31 October 2012

APPLICATION FOR THE PROPOSED ABLE MARINE ENERGY PARK BY ABLE HUMBER PORTS LTD: Ref TRO 30001

I attach my analysis in which I have formed the view that whilst the new proposals go some way towards resolving previously highlighted problems, the overall package remains flawed in several ways:

APPENDIX 1
EXPLORATORY HOLE LOCATION PLAN
(Delta Simons)

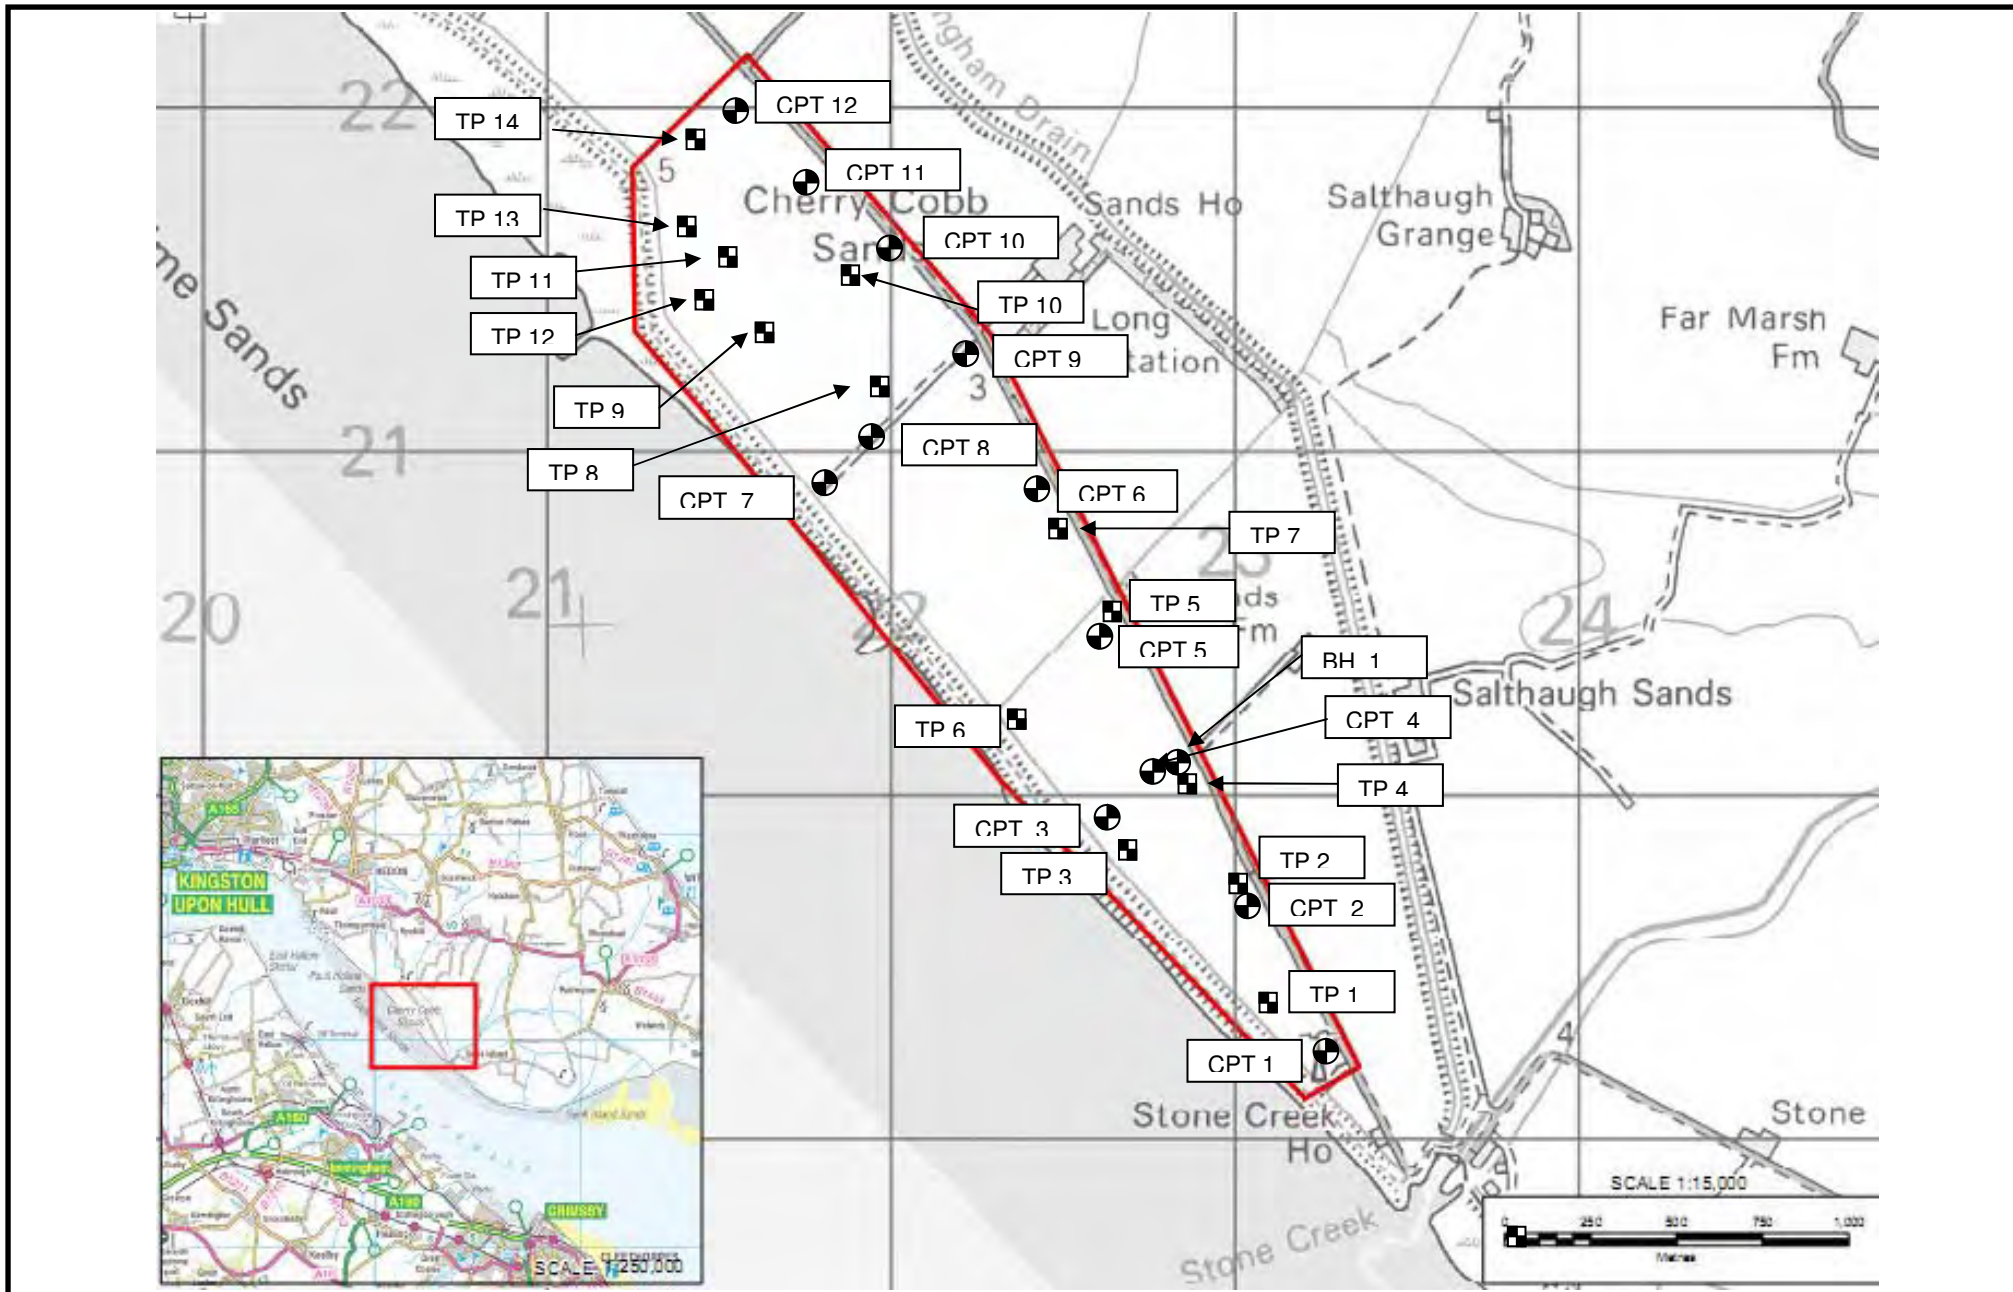
You will also be aware that we have repeatedly raised concerns about contaminated land and the ways in which this issue has been addressed. As far as we can see, the issues raised in report EX31.5A do not seem to have been addressed elsewhere. This report highlights the presence of demolition waste, pharmaceutical waste, rubble, possible asbestos, rebar and wire, and detection of an 'oily latex smell'. Surely there is a need to consider possible removal and disposal to a hazardous waste disposal facility?
